Subject: OBJECTION :Planning Application 3/2024/0196 Approval of details reserved by

Conditions 9 (surface water sustainable drainage scheme) and 17 (boundary

treatment) of planning permission 3/2019/1104.

Objections to discharge of Condition 17 - 3/2019/1104

Drawing Title		Date	Scale	Drawn / Checked by
2500 Screen & Trellis		02/24	1/20@A3	-
Drawing Status		Drawing Ref	Rev	
Planning Detail		LSD.BT.F05.05	-

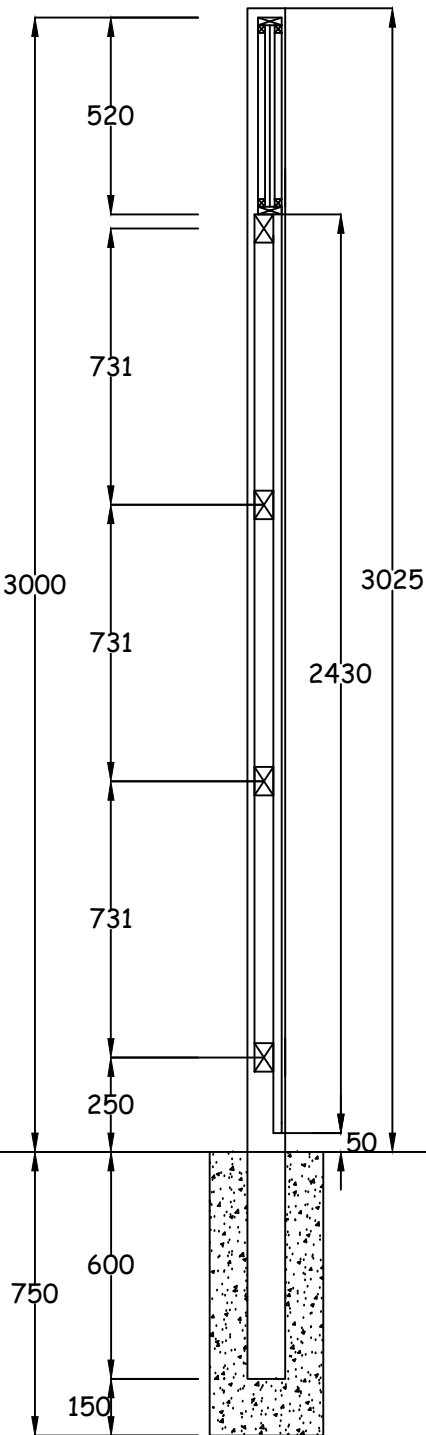
Rev O - The proposed fence heights whilst increased is not acceptable for most if not all adjacent properties.

For example, due to the FFL levels of Plot 57 being 1.75m higher than the original ground level, the proposed boundary treatment of "2500mm close boarded fence with trellis" does not offer adequate screening to protect the privacy of the existing properties on the Park Avenue boundary - diagram and pictures below.

Summary: The fence height proposed is only approx. 0.67m higher than the current fences of fences. Therefore due to the increased heights of plots 53-57 against the original ground level the proposed fence heights will not stop the new houses and any street view from the new properties seeing directly

Drawing Title
Surface Water Displacement Plan

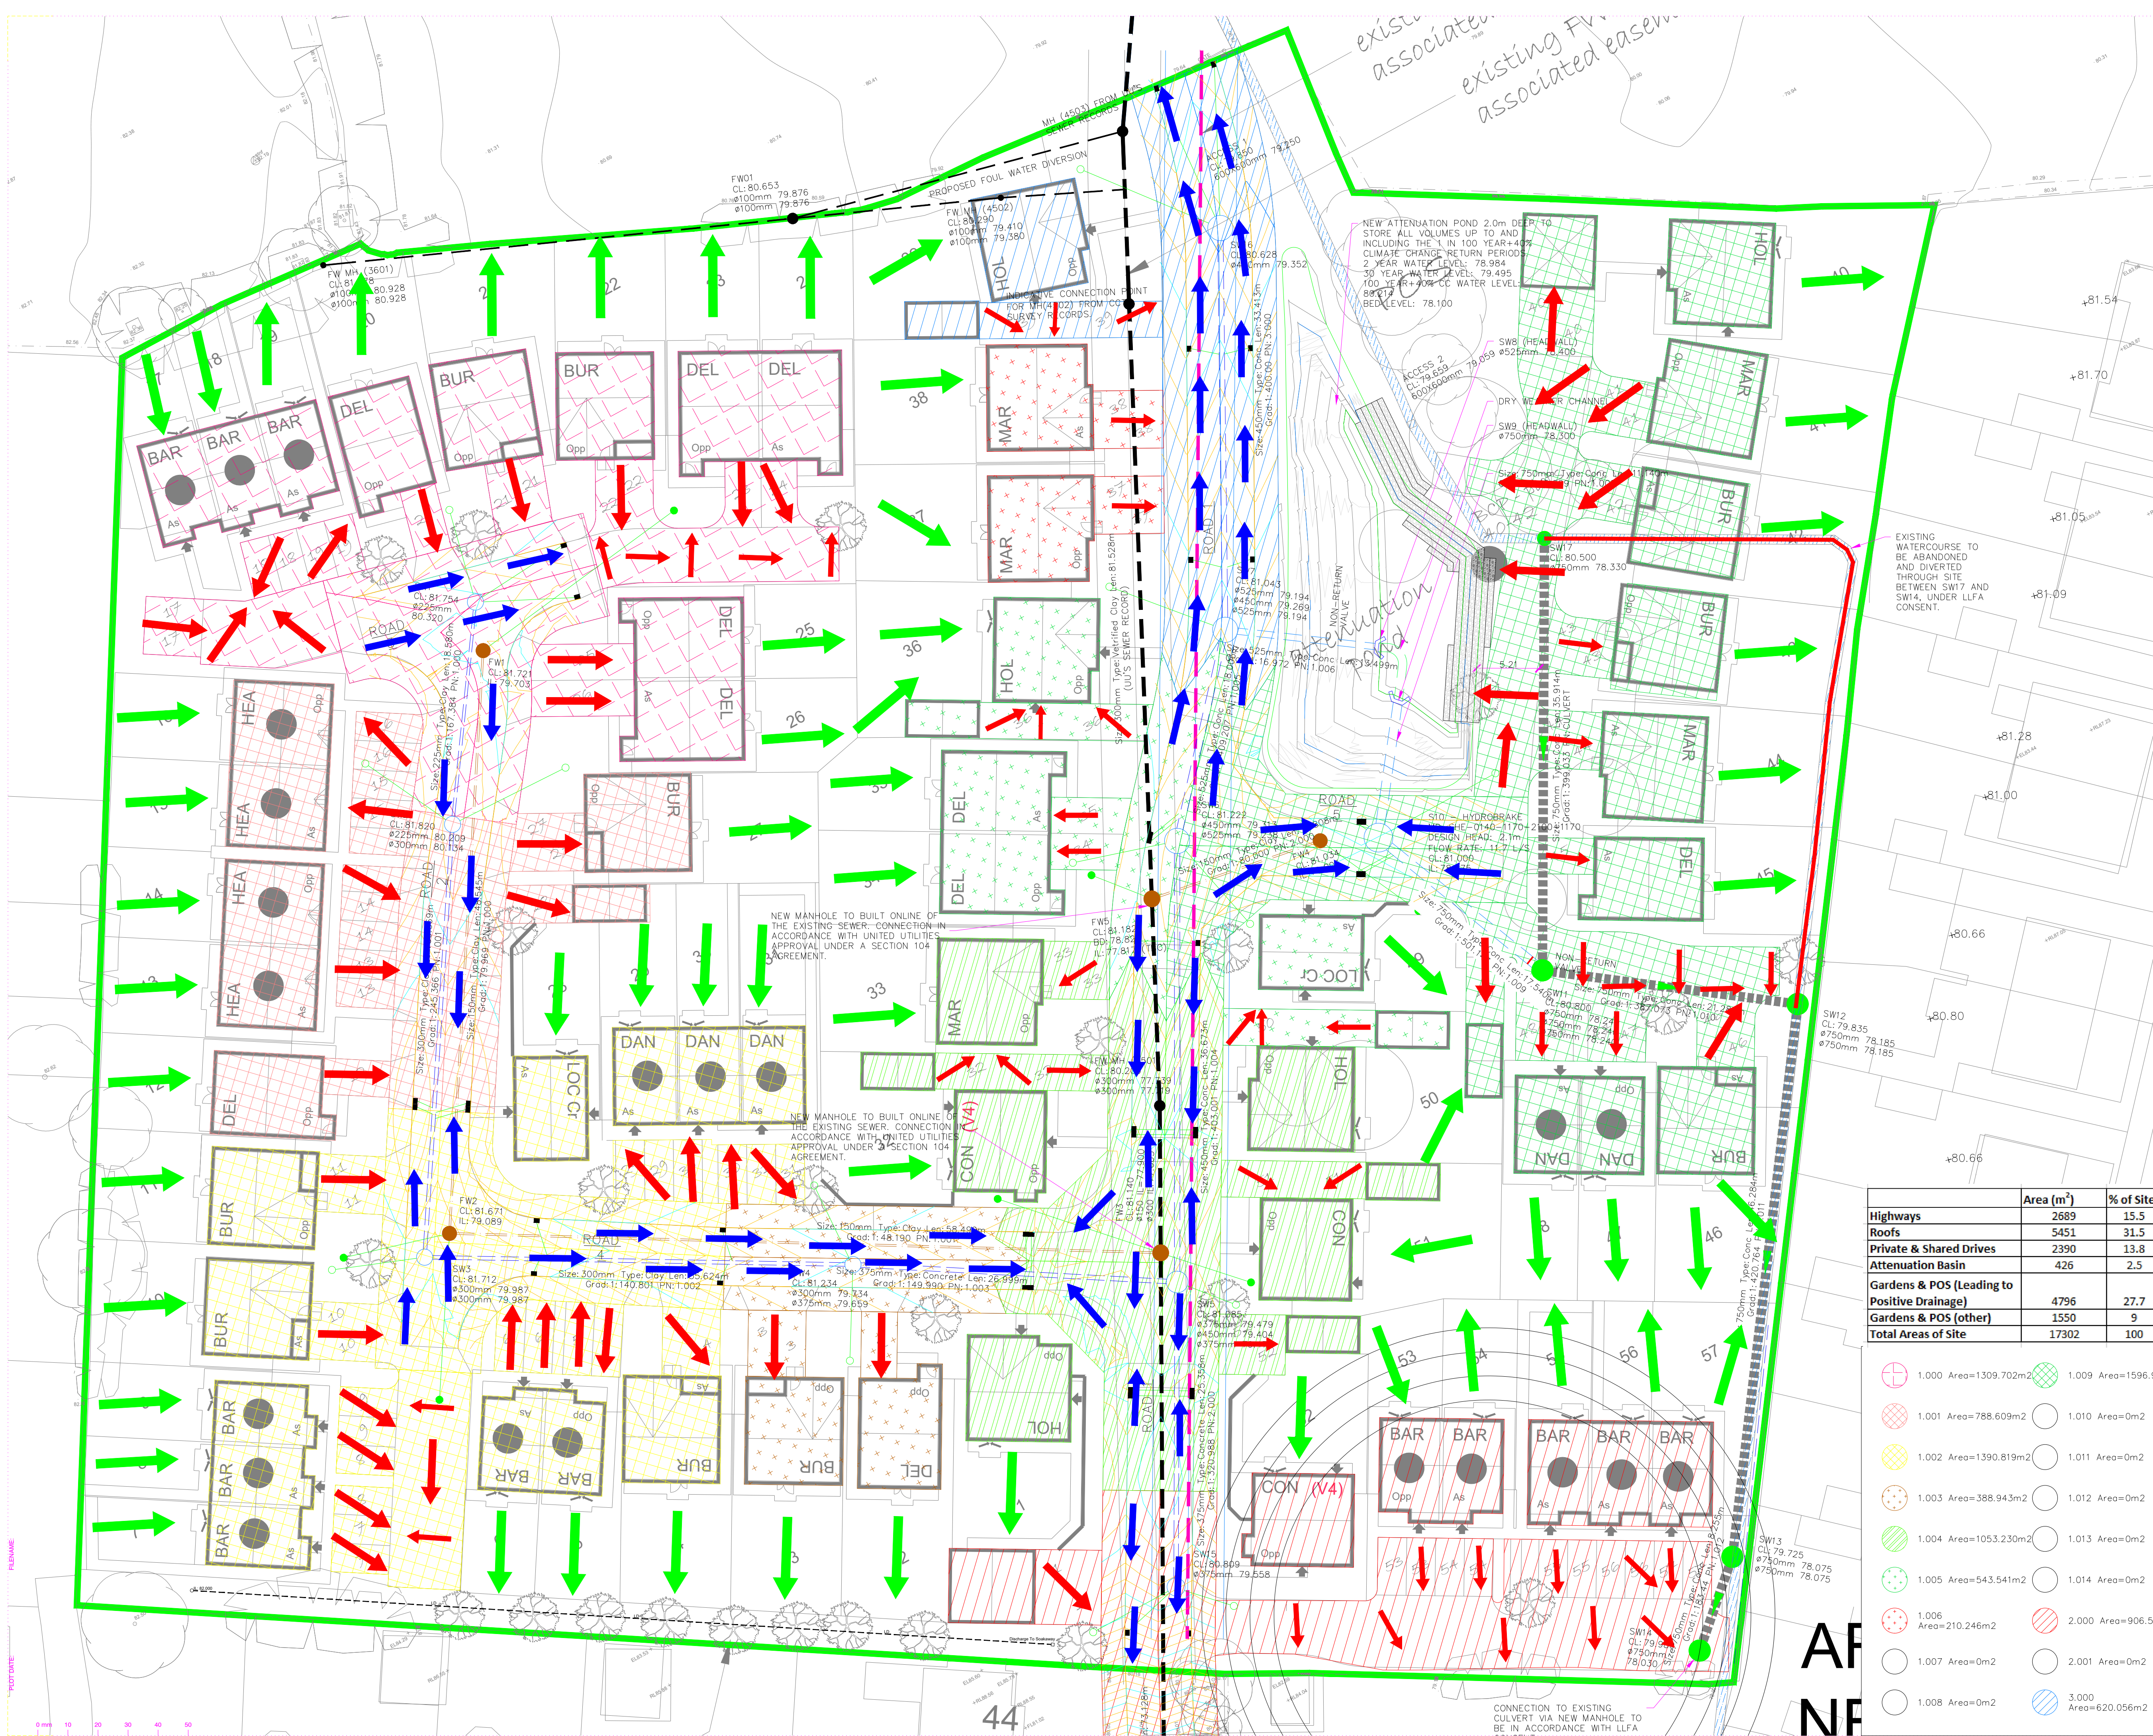
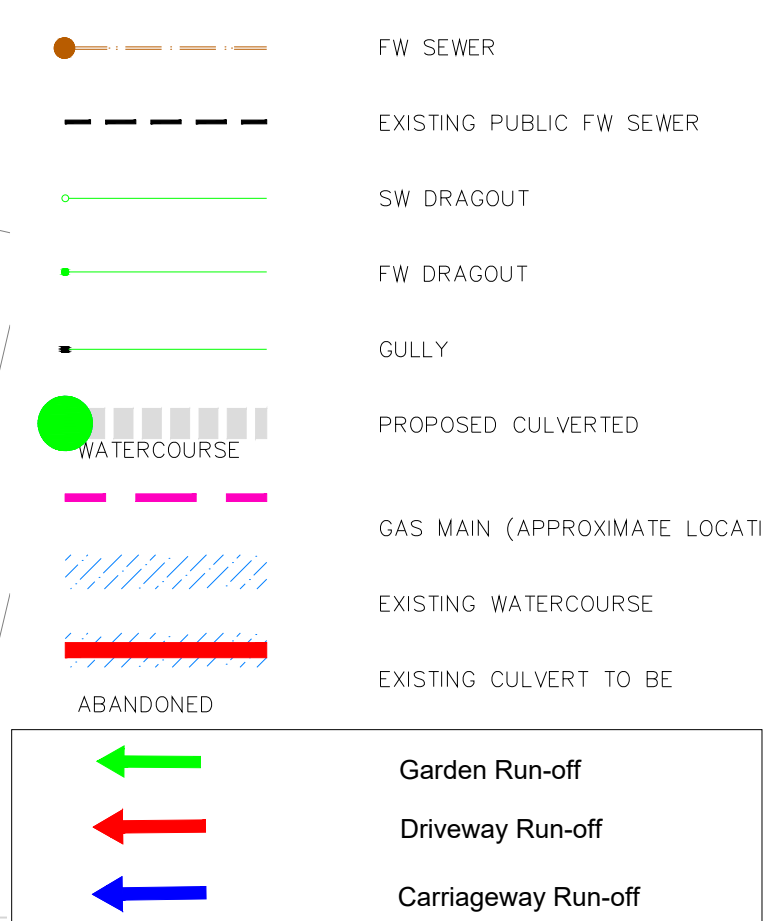
A surface Water Displacement plan – 19310.C2004

Rev P02 - No update in the comments as to why the document submitted has moved to REV P02
 Why?
